**KIRKLEES METROPOLITAN COUNCIL  
INVESTMENT & REGENERATION SERVICE**

**Reference No:** 2020/44/90441/W

**Site Address:** Pennine Service Station, Bradley Road, Bradley,  
Huddersfield, HD2 1QD

## **Officer Report: 2020/90441**

Workplane (Site) / Perpendicular illuminance (adaptive)**Workplane (Site): Perpendicular illuminance (adaptive) (Surface)****Light scene: Light scene 1**

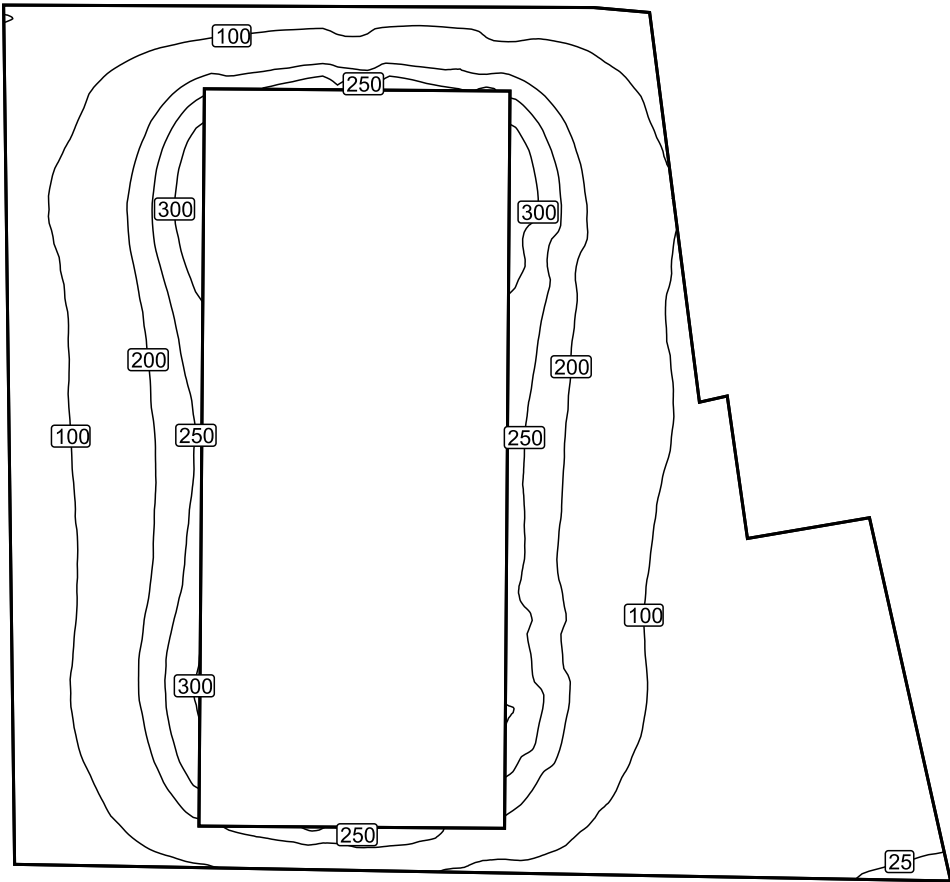
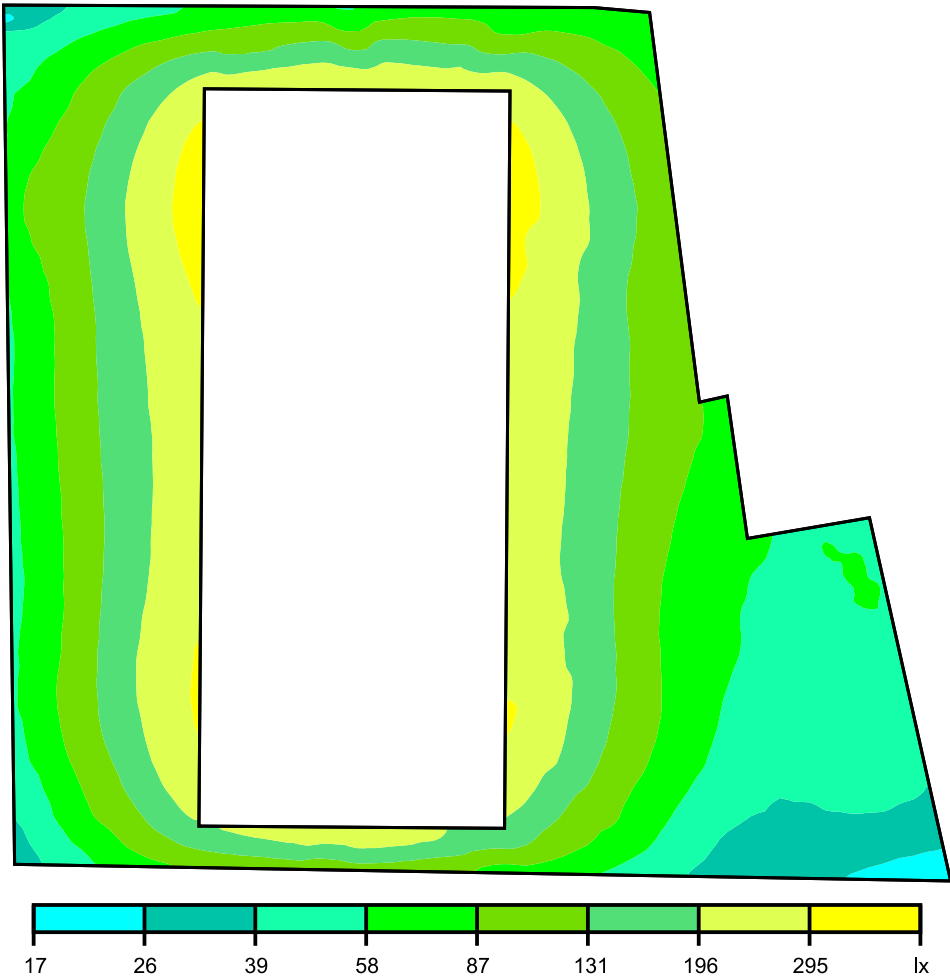
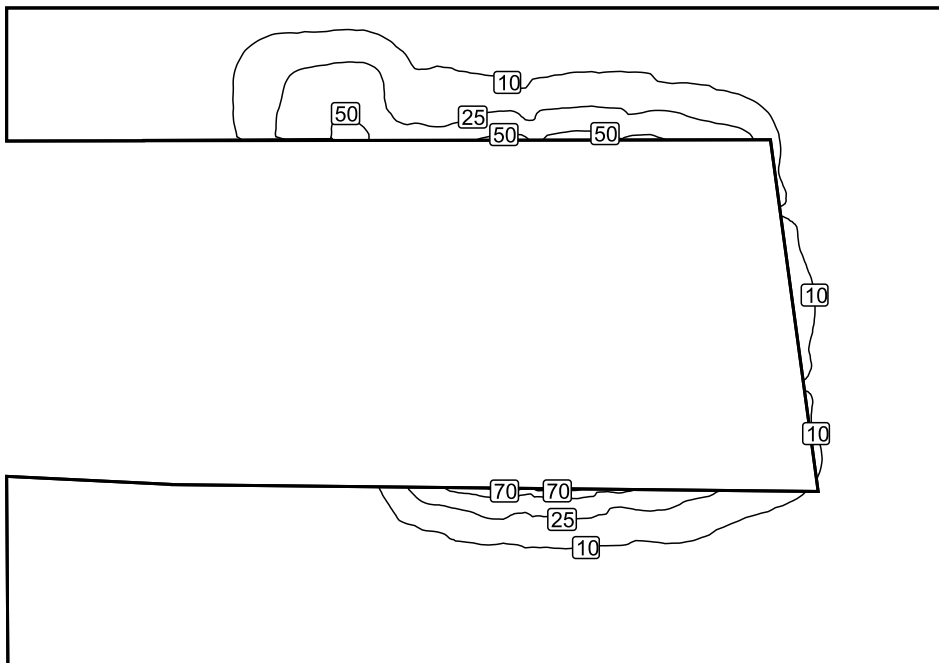
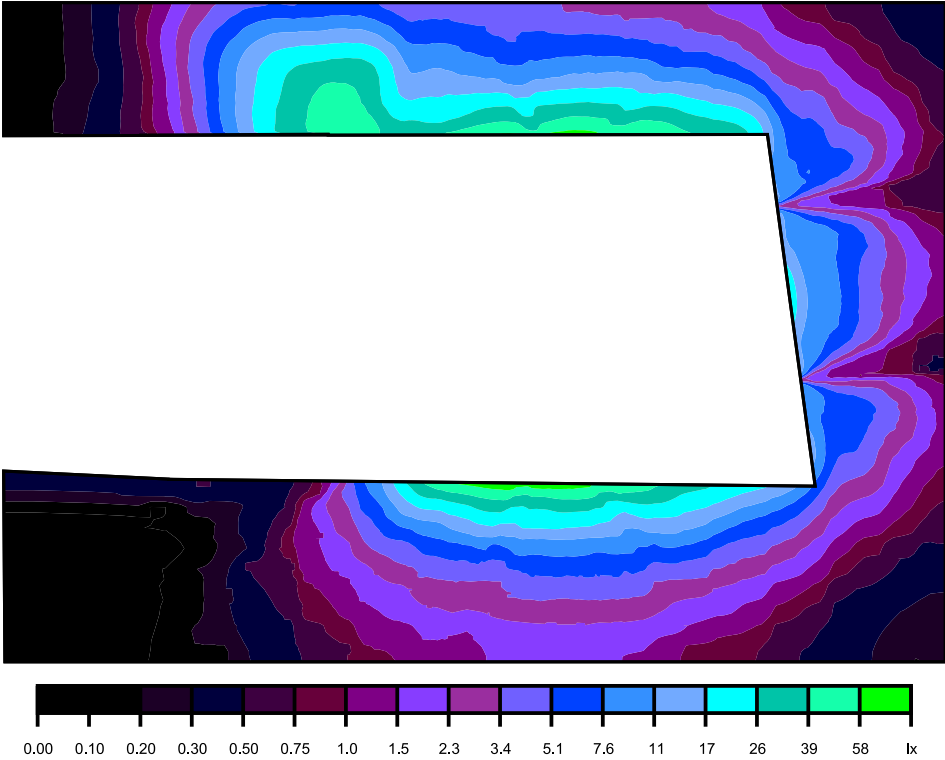
*In the email there is now a reference to guidance in BS EN 12464-2:2014 Light and lighting — Lighting of work places Part 2: Outdoor work places. He refers to Table 5.6 for fuel filling stations that the maintained level of illumination is 150 lux.*

*Table 5.6 actually recommends 150 lux at air pressure and water checking points and other service areas and 20/50 lux at dark/light environment entry and exit driveways and 5 lux at parking areas. The information provided by the applicant does not specifically give the maintained levels of illuminance at these various points at the site. However, from page 8 of the previously submitted lighting scheme it appears that the average illuminance at areas not under the canopy will be 84 lux and from page 9 the isolux contours appear to show the entrance and exit driveways will be around 50 lux. The proposed lighting does however appear to provide insufficient illuminance levels of 25 lux at air, water and charging service points.*

*Environmental Health's main concern is related to ensuring that the lighting does not adversely affect the amenity of nearby residents. The proposed levels of illuminance have now been shown to be at levels that, compared to guidance in BS EN 12464-2, are not excessive. The proposed levels of horizontal illuminance for the area outside the canopy are therefore considered to be satisfactory.*

The report refers to perpendicular lighting levels but gives no indication what it is perpendicular to. I also require the horizontal illuminance levels for the site (with some reference to guidance to demonstrate that they are appropriate

Proposed Service
Station, Bradley Road,
Huddersfield

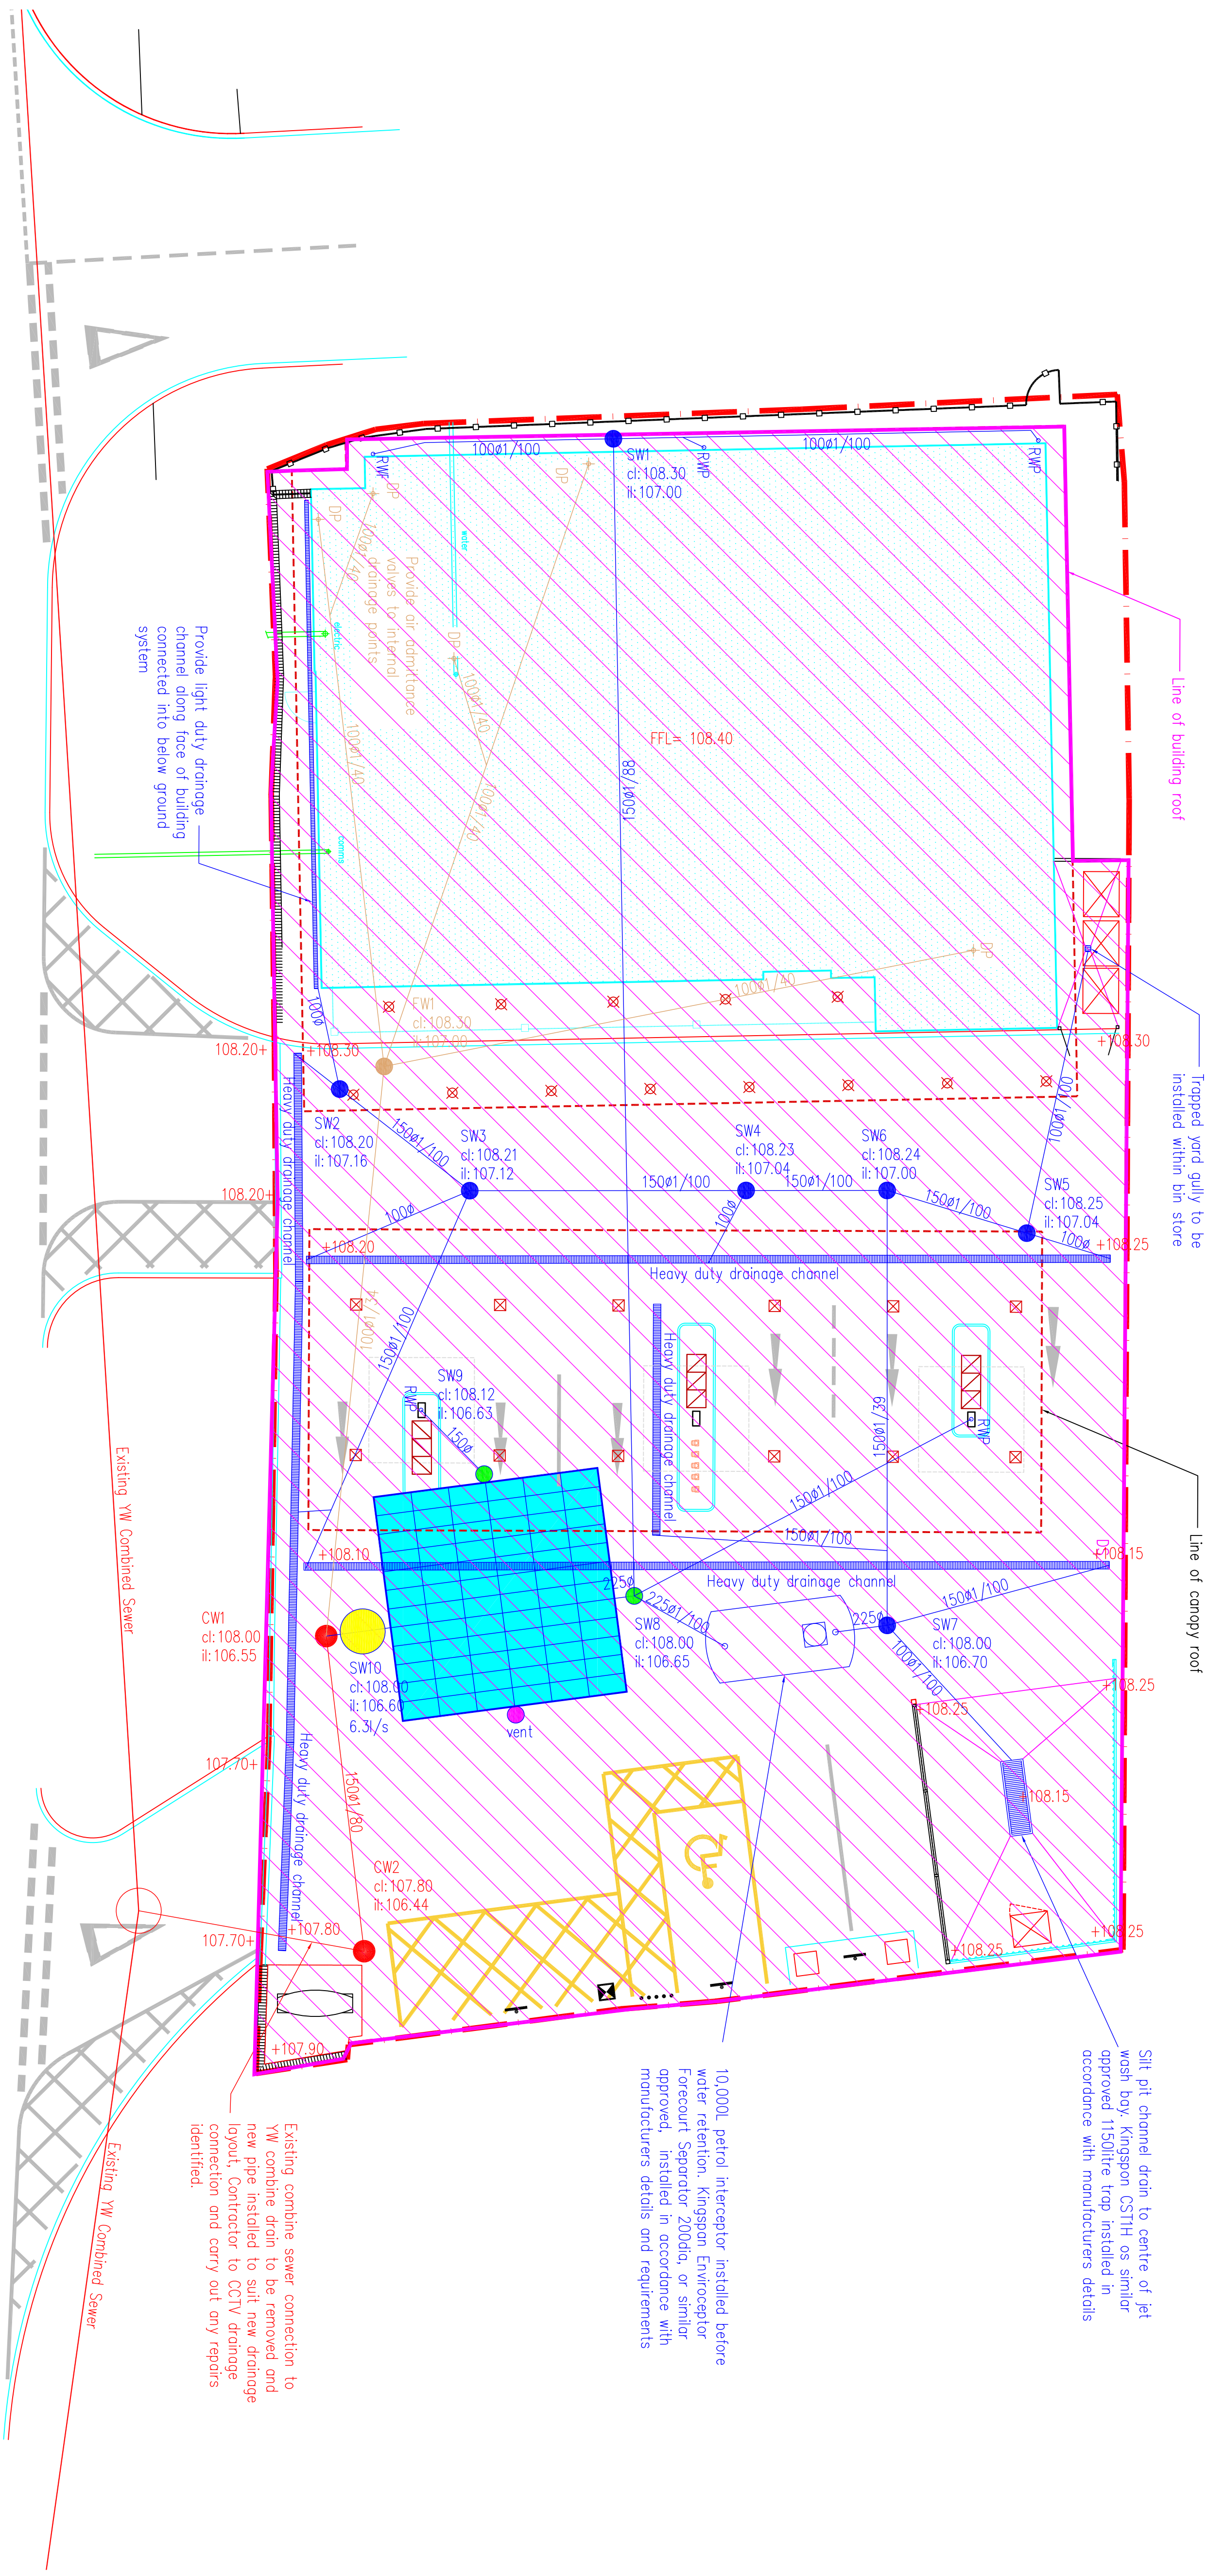
1. Annotations for the attenuation tank on plans show conflicting information. Kirklees LLFA have **no objection to an attenuation tank sized 42m<sup>2</sup> x 0.8m deep**. Any other annotations are not approved;

2. The cover depth (ground surface to top of pipe/tank) for the attenuation is proposed to be between 0.75m and 0.8m. It is the applicant's (and their engineers') responsibility to ensure the design is safe and suitable for the site use and operation. The LLFA have not instructed any design, but required the applicant to confirm appropriate cover above the attenuation tank to be resistant to vehicle trafficking. The liability for the design lies with the applicant's design engineer and any damage or failure of the system is their responsibility.

Officers note an inconsistency on the annotations relating to the attenuation tank, showing different sizes. Kirklees Local Planning Authority have no objection to an attenuation tank sized 42m<sup>2</sup> x 0.8m deep. Any other annotations are not approved.

The cover depth (ground surface to top of pipe/tank) for the attenuation is proposed to be between 0.75m and 0.8m. It is the applicant's (and their engineers') responsibility to ensure the design is safe and suitable for the site use and operation. K.C. Planning and K.C. Lead Local Flood Authority have not instructed any design, but required the applicant to confirm appropriate cover above the attenuation tank to be resistant to vehicle trafficking. The liability for the design lies with the applicant's design engineer and any damage or failure of the system is their responsibility.

Kirklees LLFA make the following comments on the Drainage Layout drawing:

- Details of the 'light duty' and 'heavy duty' channels should be included in the drawing. This should include the type, levels, sizing and length;
- There should be manhole chambers placed in locations where the lateral drains are connected to the piped system;
- Water from the jet wash bay should not be connected to the surface and rain water system, as it is not classed as rain water and could result in siltation. A separate connection is required or a connection downstream of a Surface water flow control. The applicant should consult with Yorkshire Water as the jet wash may require a flow control and similar storage.

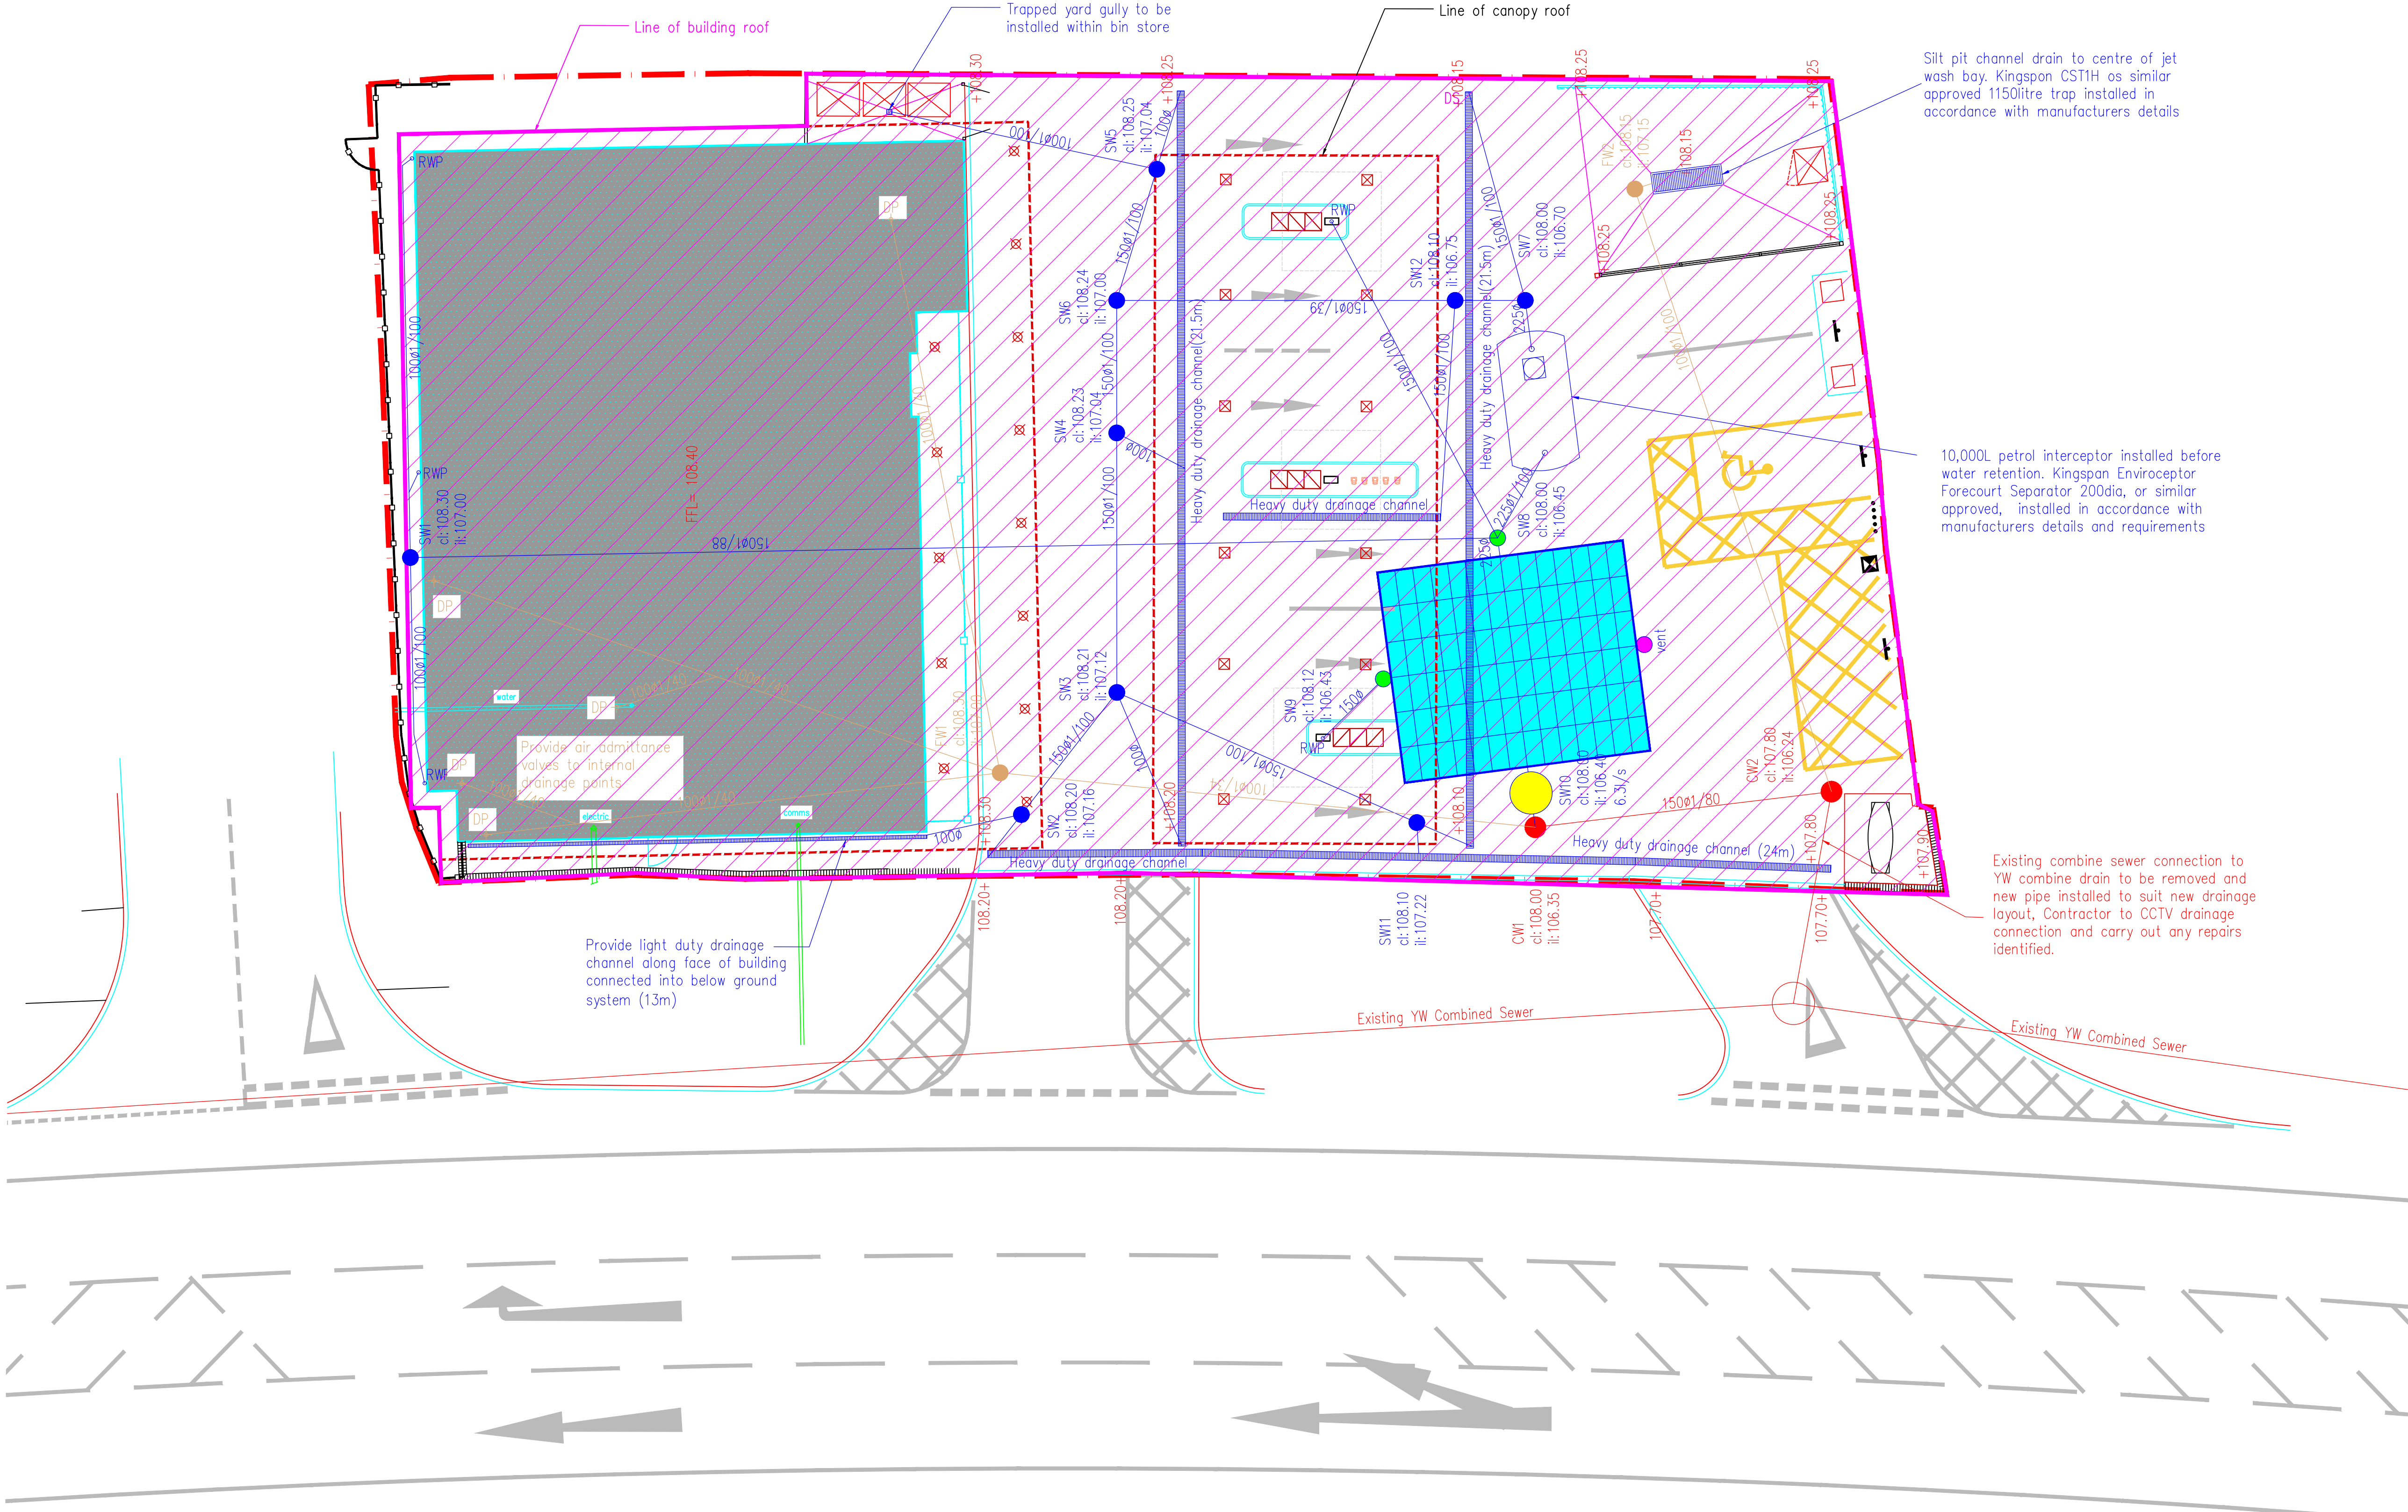
Kirklees LLFA make the following comments on the Drainage Details drawing:

- Following implementation of the comments for the above two documents, this drawing should also be updated and provided for review.
